SANDSTONE PRECINCT

DESIGN REVIEW PANEL - ADVICE 1

7 June 2016

DESIGN REVIEW PANEL - ADVICE 2

EDUCATION BUILDING - GLASS BAY

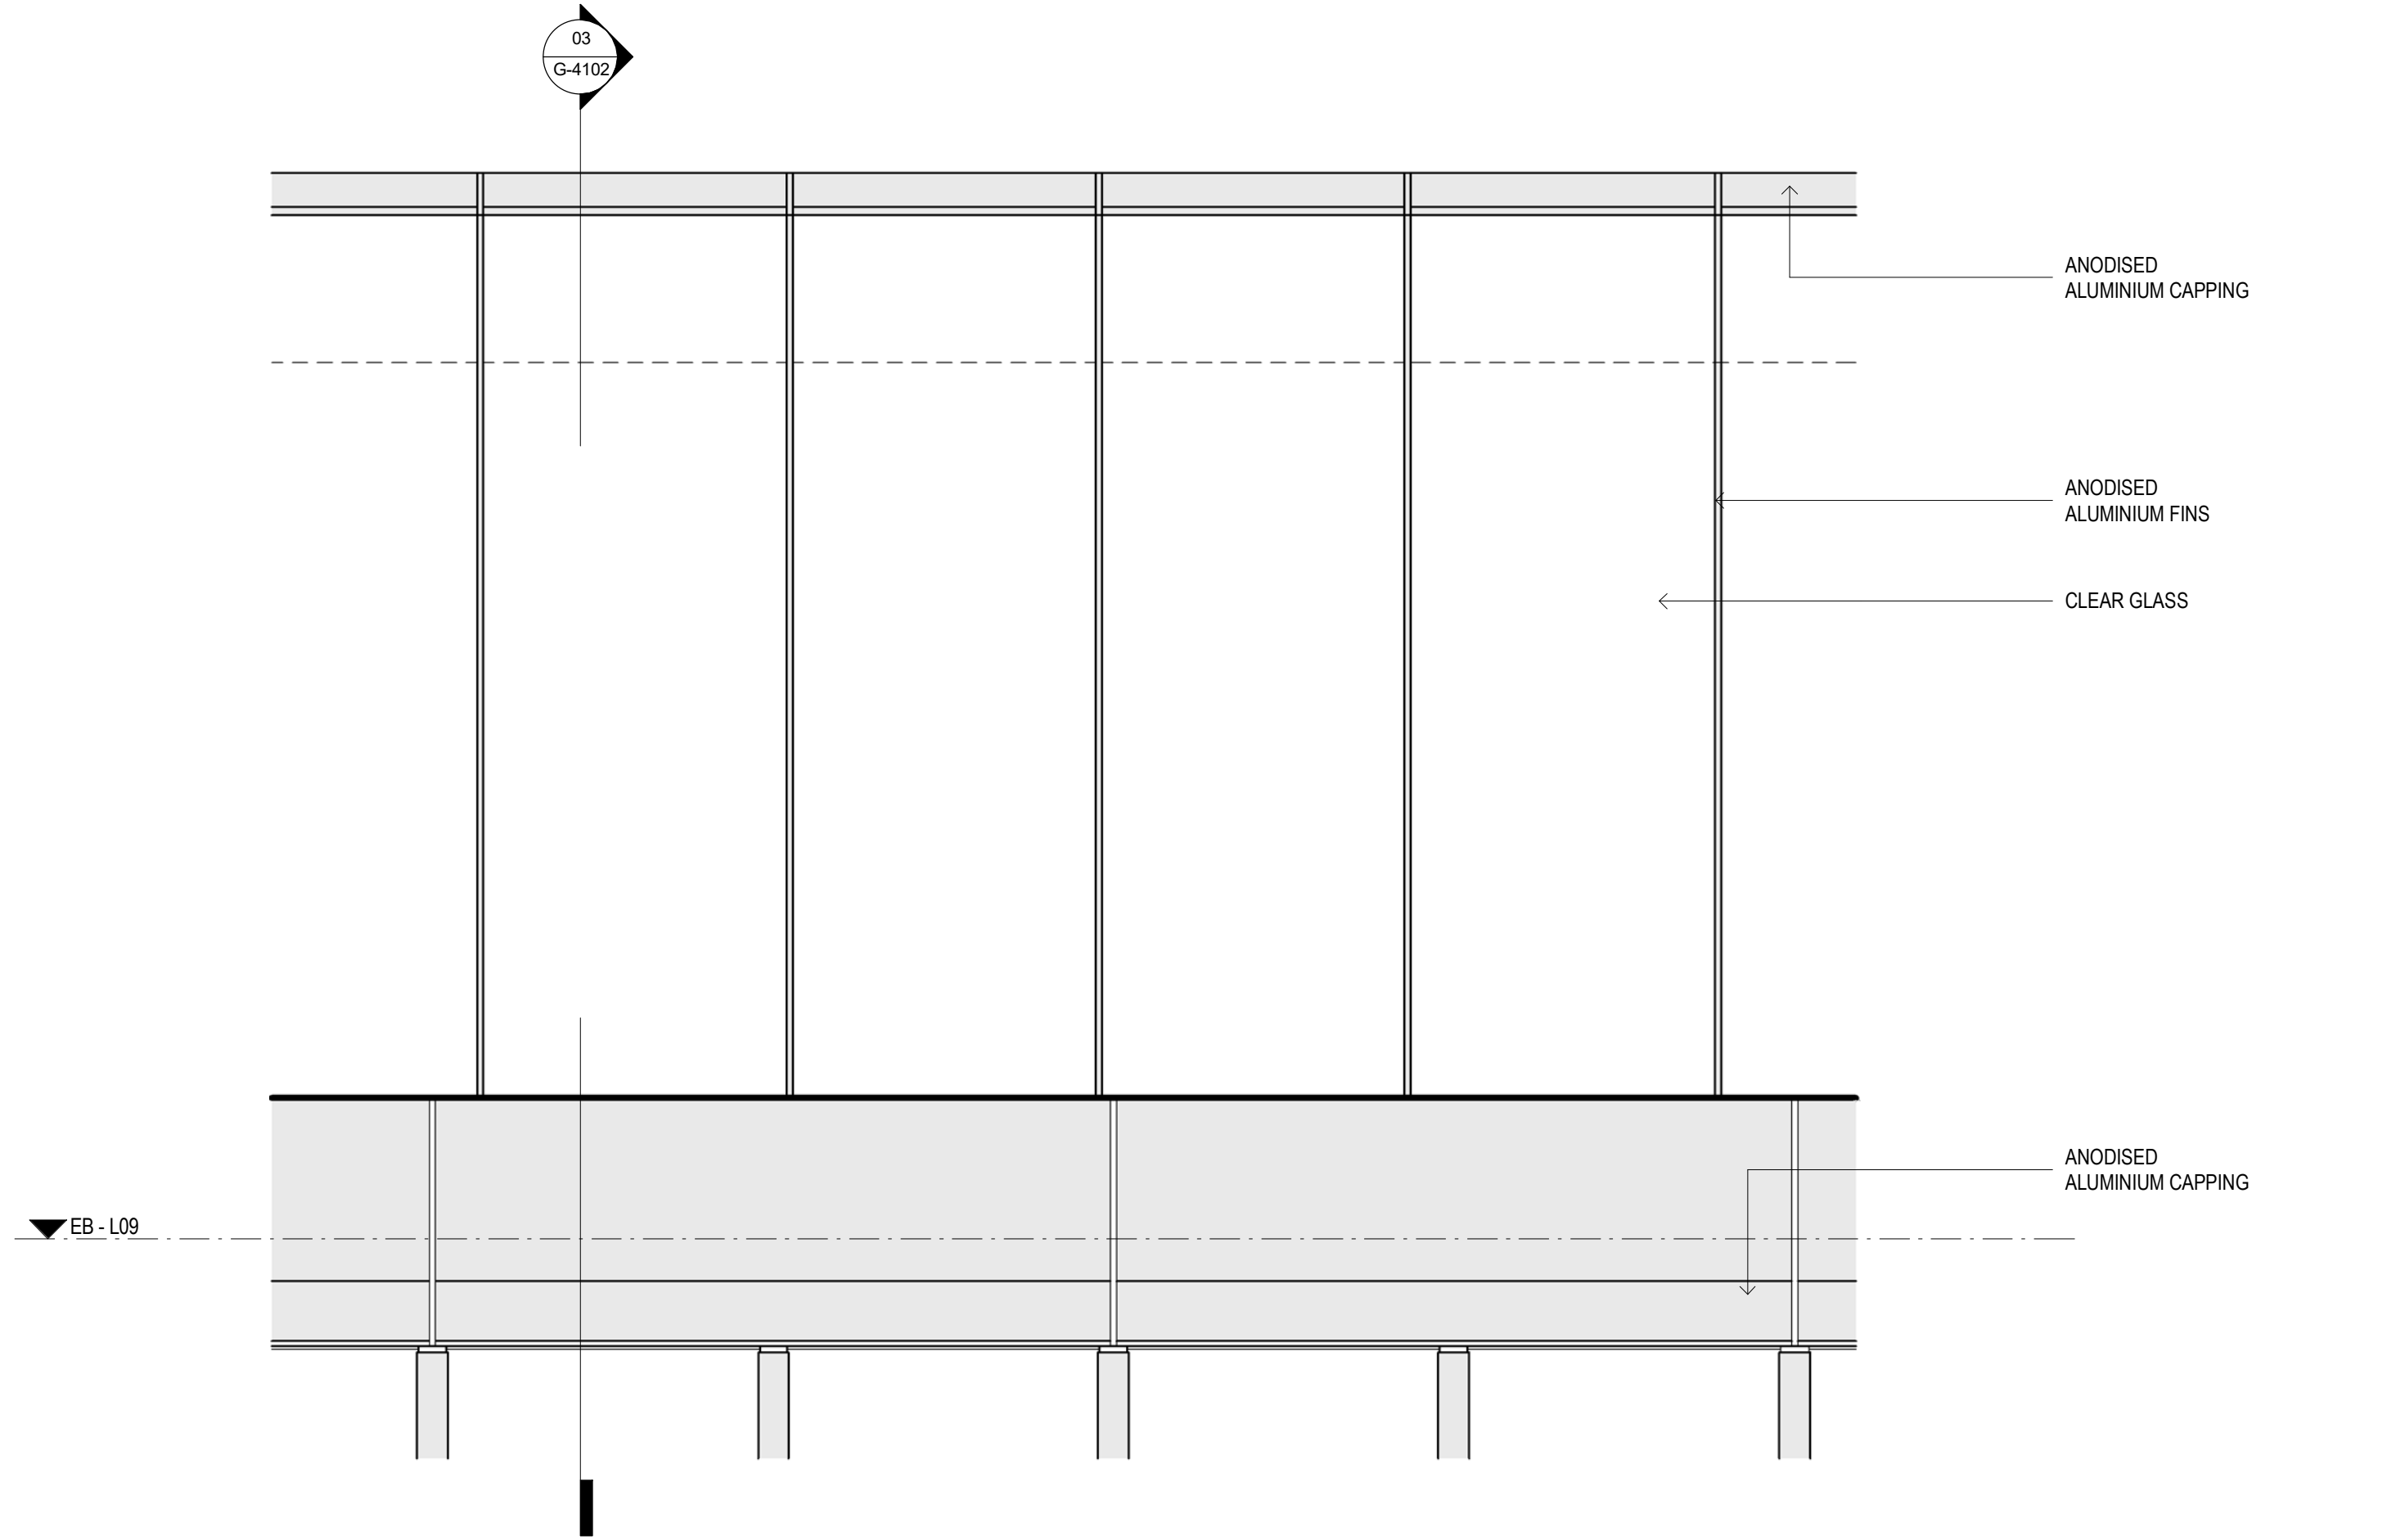
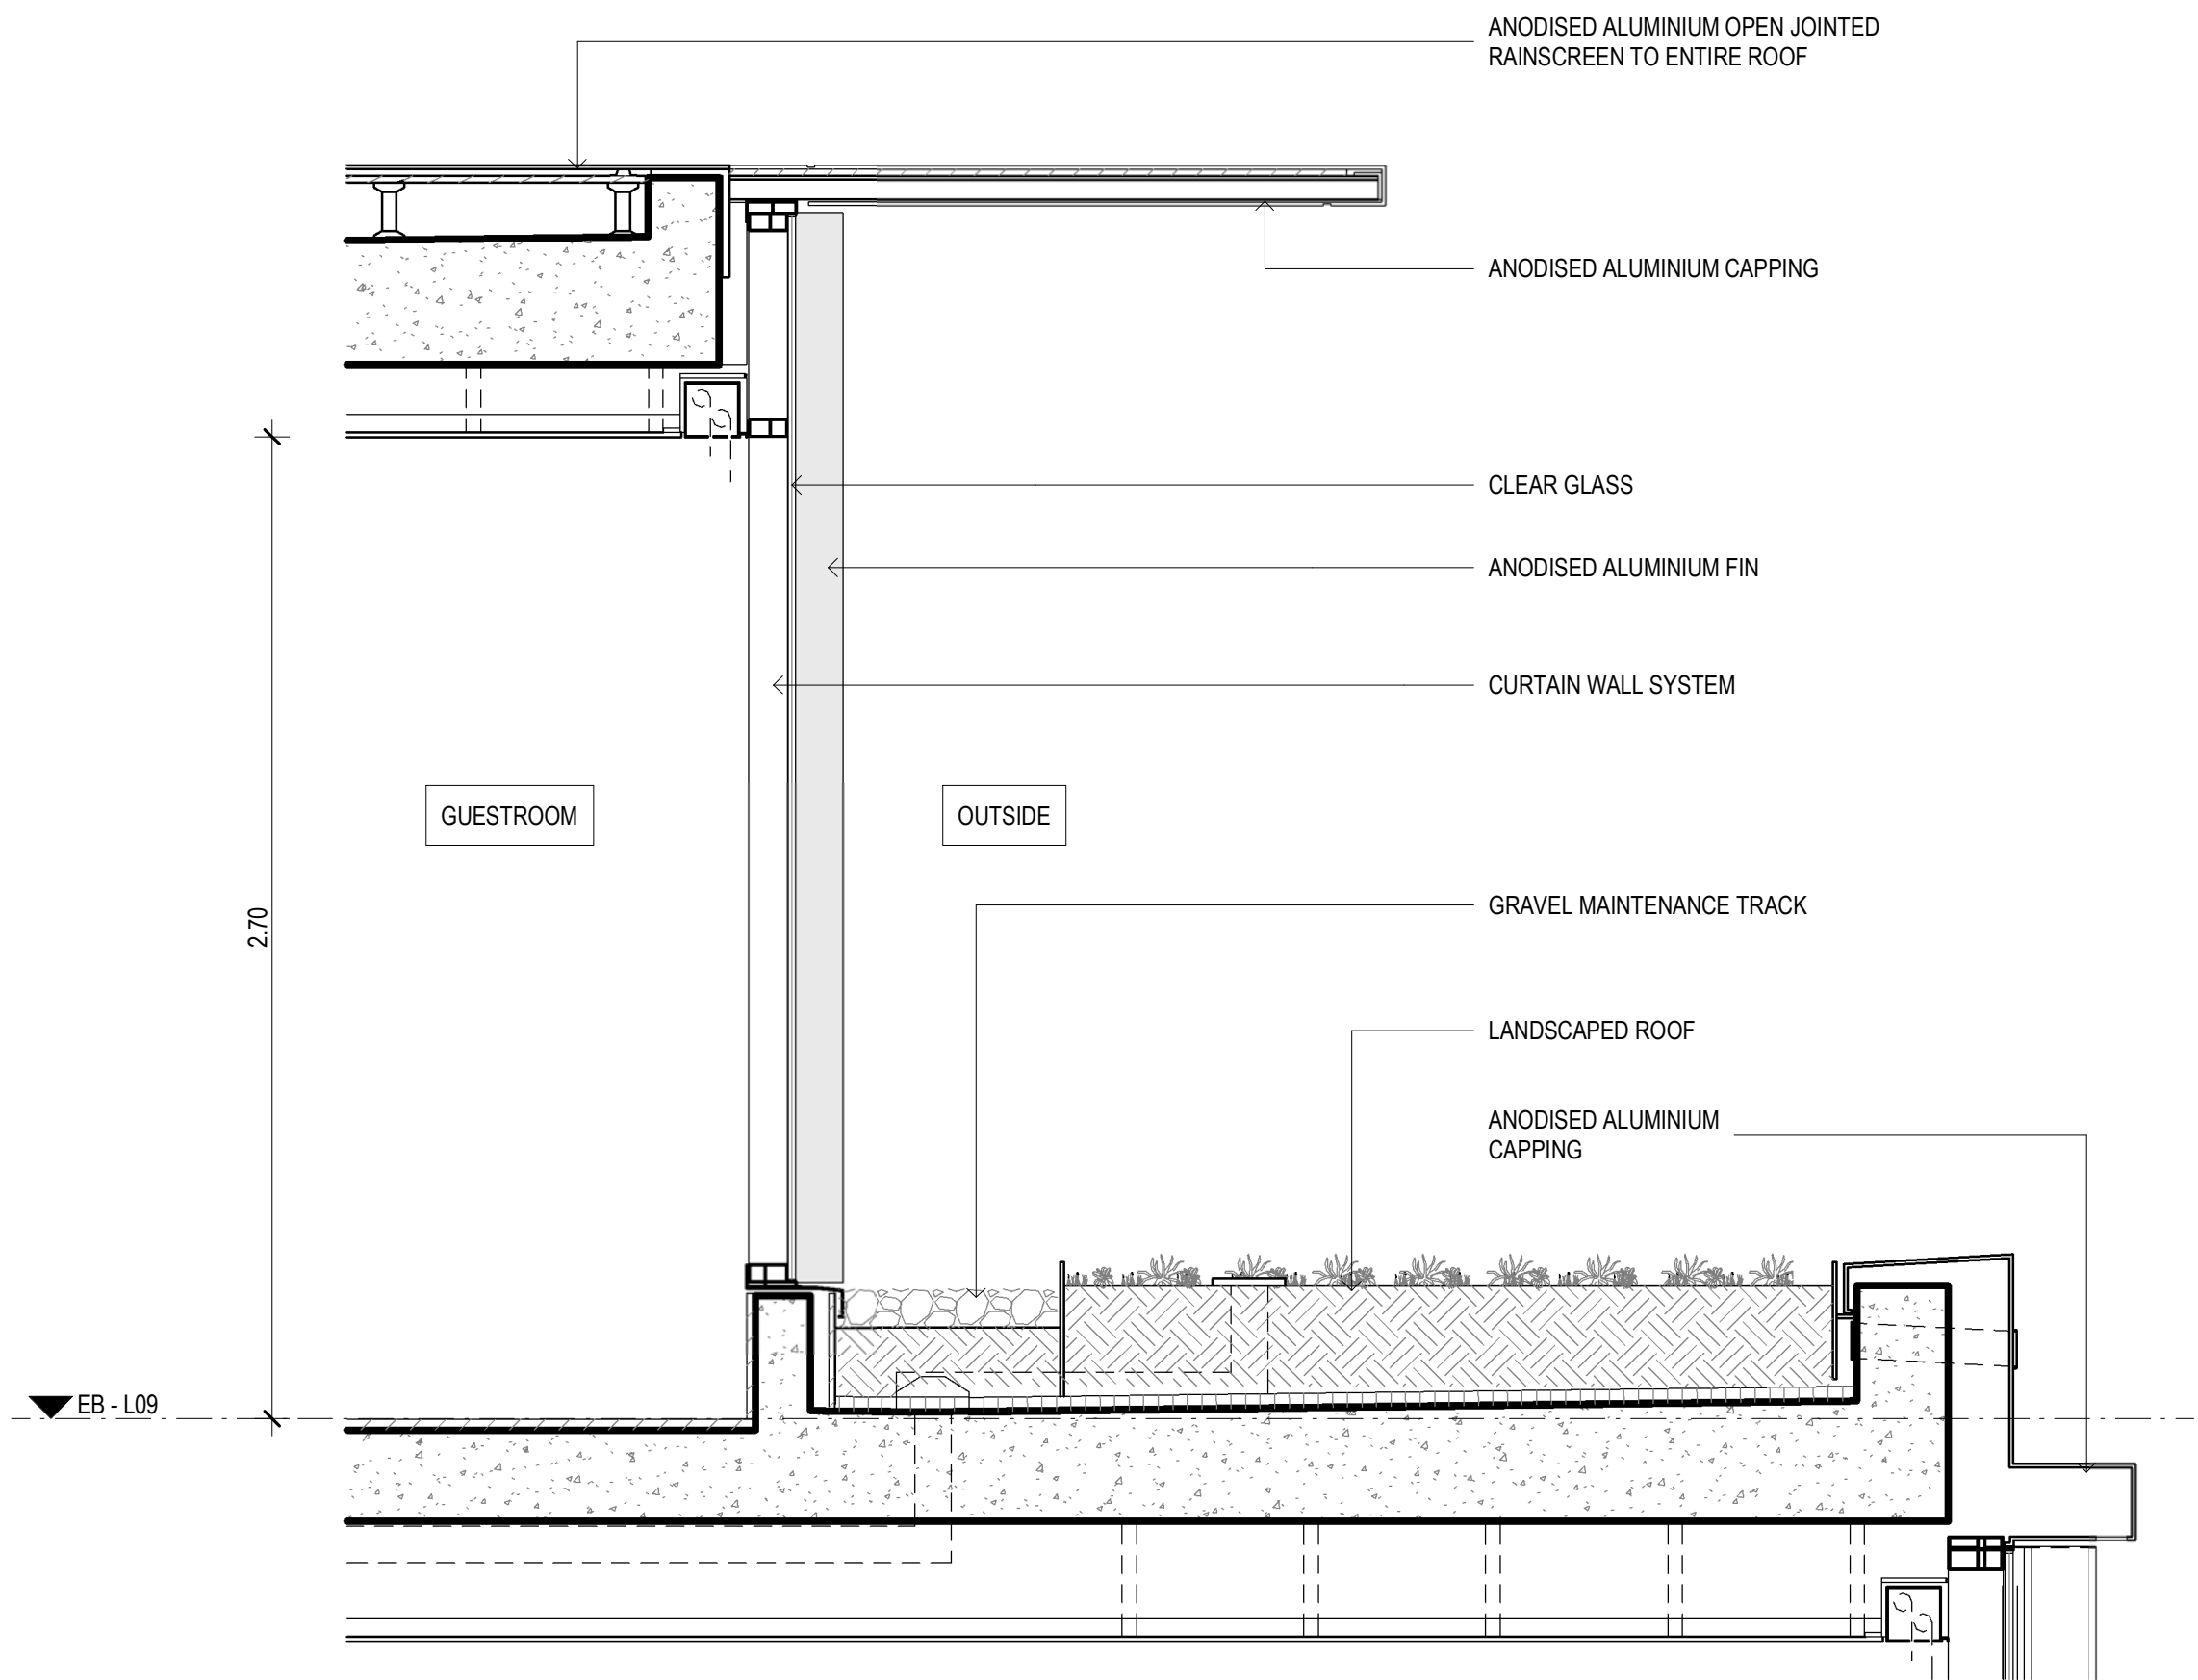
- Panel members raised some concerns over the curved glass on the upper floor extension. These included issues of reflectivity, night image, lighting, and environmental performance, and requested further detail relating to these issues
- There was concern too about the glass boxes on the roof to the east and west. Further information is needed to fully understand their internal planning and detailing of materials, and how issues of sun control, privacy and lighting are managed.
- Environmental performance of the building, particularly during summer within the topmost rooms considering the wide use of glazing and glass roof. The panel would like to see more information from the environmental engineer.

- The Education Building upper level facades were discussed. The Panel requested further investigation, design development and perspective views. Items to be considered include the spacing design and colour of the mullions, the capping roof of the cooling towers, a possible capping to the rebuilt rendered facade, fluted stone details, the glass specification, colour, type of internal window treatment and environmental performance.

- the glass specification, colour, type of internal window treatment and environmental performance need to be clarified - ongoing.
- New detailing for glazed courtyard roof is supported by the Panel.
